**RE: Wilson Short Plat, File Number SP-07-14**

Kittitas County Community Development Services has determined that the Wilson Short Plat (SP-07-14) is a complete application and hereby grants **conditional preliminary approval** subject to the following conditions:

TO: Mike Elkins, Community Development Services  
FROM: Christina Wollman, Planner II *cw*  
DATE: January 3, 2008  
SUBJECT: Wilson Short Plat SP-07-14

SHORT PLAT NO. SP-07-14
KITTITAS COUNTY, WASHINGTON

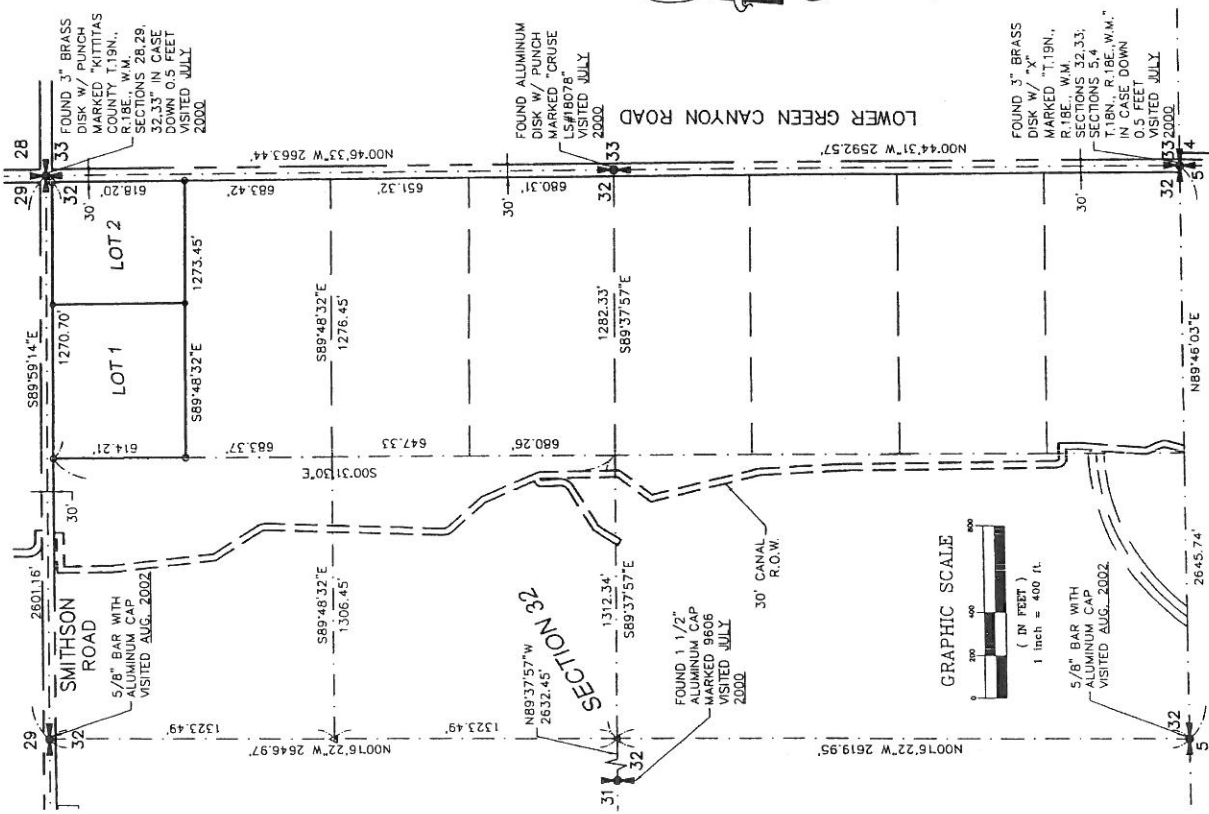
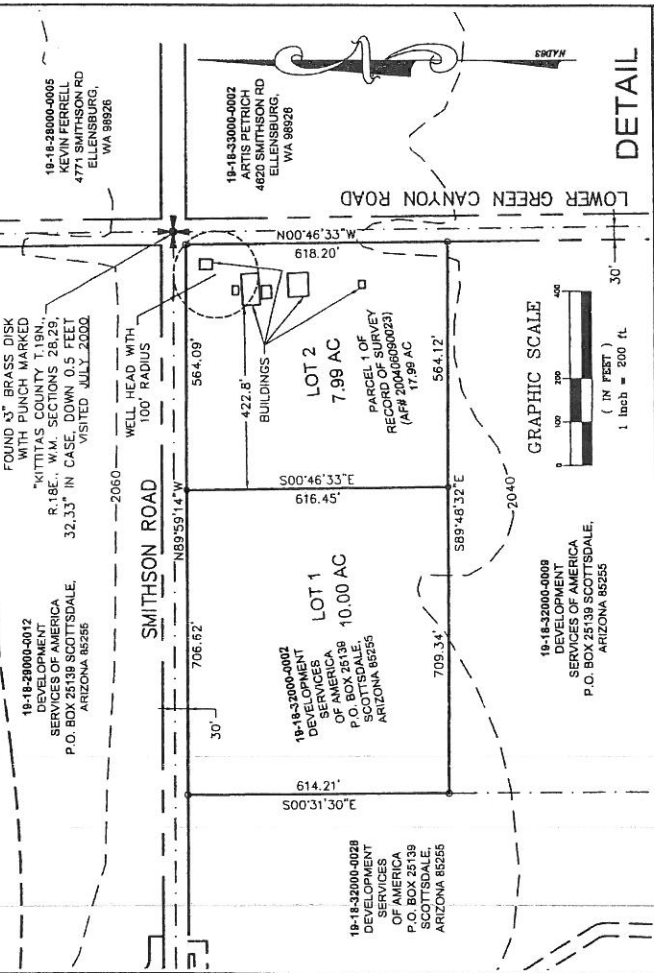
- 1) Both sheets shall reflect Short Plat Number **SP-07-14**.
- 2) The location of all existing ditches, whether apparent or of record, shall be depicted on the final mylars in accordance with Kittitas County Code 16.12.030 (C).

- 3) All existing fences located on the subject property shall be clearly depicted on the final mylars in accordance with Kittitas County Code 16.12.030 (D).

- Lot 1 of the Wilson Short Plat is affected by a potential PEMC Wetland (Palustrine Emergent Seasonal). The location of the potential wetland shall be depicted on the final mylars drawing, and the following plat note shall be recorded on the final mylars:

3. Existing Features: The existing access for Lot 2 shall be shown on the face of the plat.
4. Plat Notes: Plat notes for each short plat shall reflect the following:

- a. Plat note #3 is incorrect and shall be removed.
  - b. Maintenance of the access is the responsibility of the property owners who benefit from its use.
